Your Ref: MP 09-0166

4 April 2011

**Environmental Assessment Exhibition: Major Project 09-0166
Residential Subdivision Frazer Drive Terranora**

Figure 1 – Bushfire Map

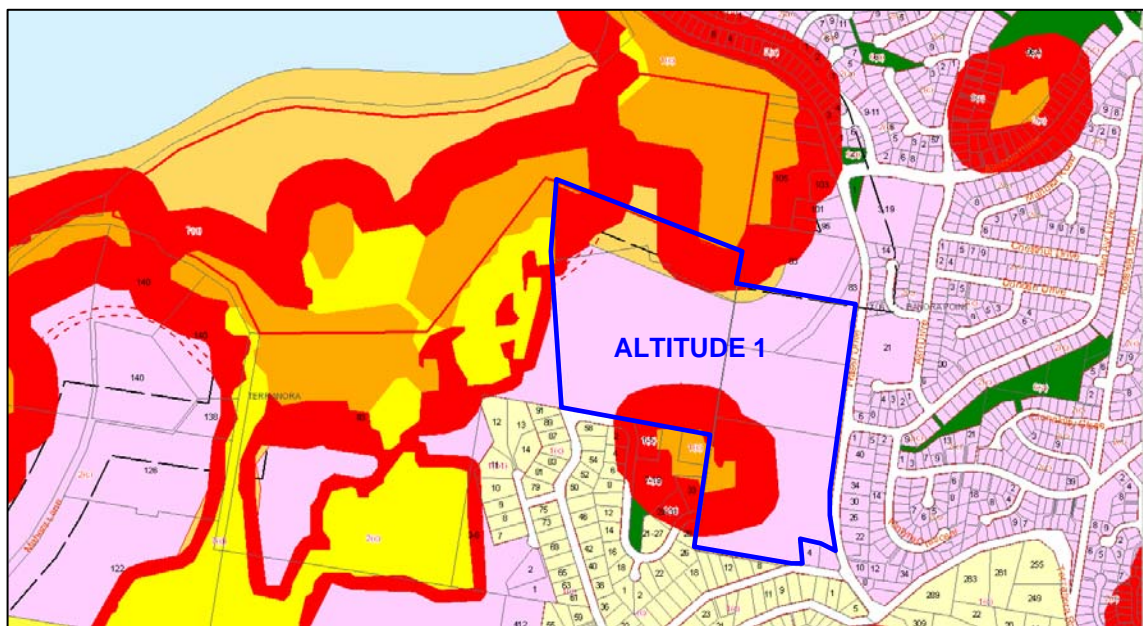
The Bushfire Assessment Report has determined that the adjoining land to the west is a "Grassland / Grassy Woodland" and has proposed a 10 metre asset protection zone (APZ) for future dwellings on Lots 1001 to 1020. 'Planning for Bush Fire Protection' requires a 15 metre APZ for woodland vegetation. In this regard the proposed APZs do not comply and aerial photography would suggest that the on going management of the adjoining grazing paddocks to the west is uncertain.

The applicant is to provide further evidence on the vegetation classification and state of management for the adjoining property to the west.

The applicant should consider the impact of the revised Australian Standard AS 3959 'Construction of buildings in bushfire-prone areas' on future dwellings constructed on proposed Lots 1001 to 1020.
